MECKLENBURG COUNTY
Park and Recreation Department

MEMORANDUM

DATE: March 23, 2023

RE: Rezoning Petition #2022-183
PID# 20520202

Rezoning Plan

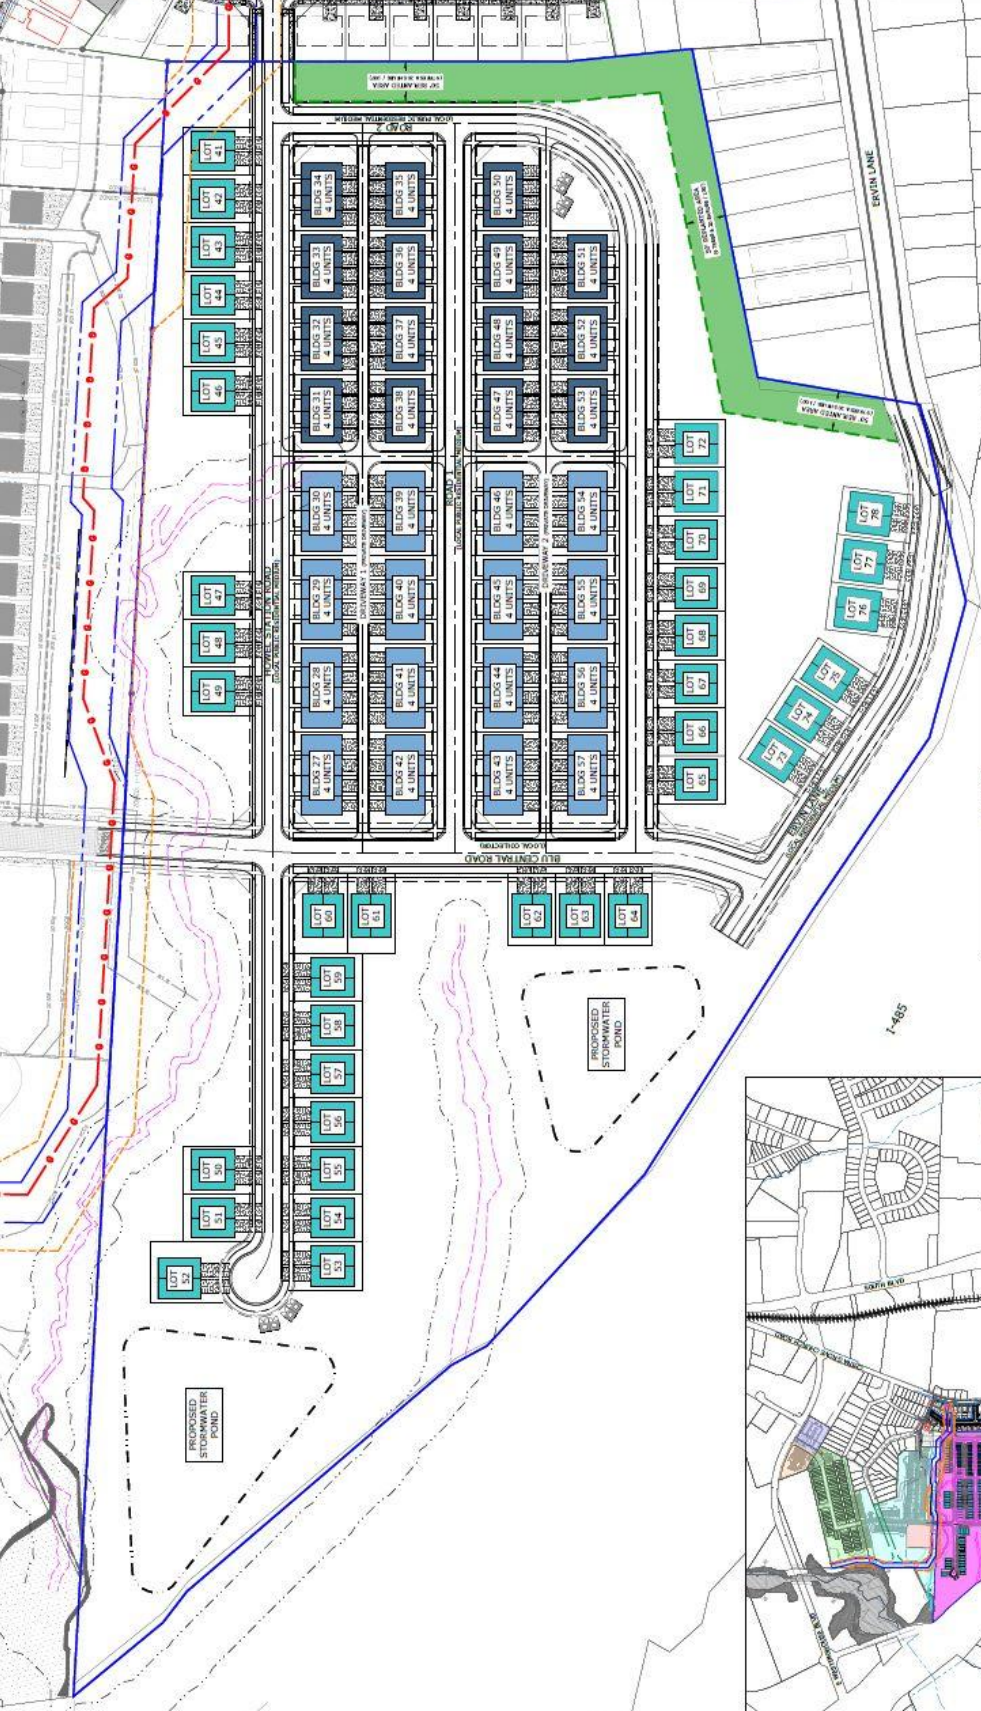
MCPR requests a minimum 60' Access Trail Easement to the future Kings Branch Greenway to be dedicated and conveyed on the west of the property as shown in Plan Room. MCPR also requests a minimum of 1.0 acre to be dedicated and conveyed to Mecklenburg County for a future neighborhood park on the east side of the property. This requested park land shall be adjacent to a public right-of-way for access and is conducive for the development of the typical amenities found in a neighborhood park and cannot include tree save parcels or stormwater BMP's.
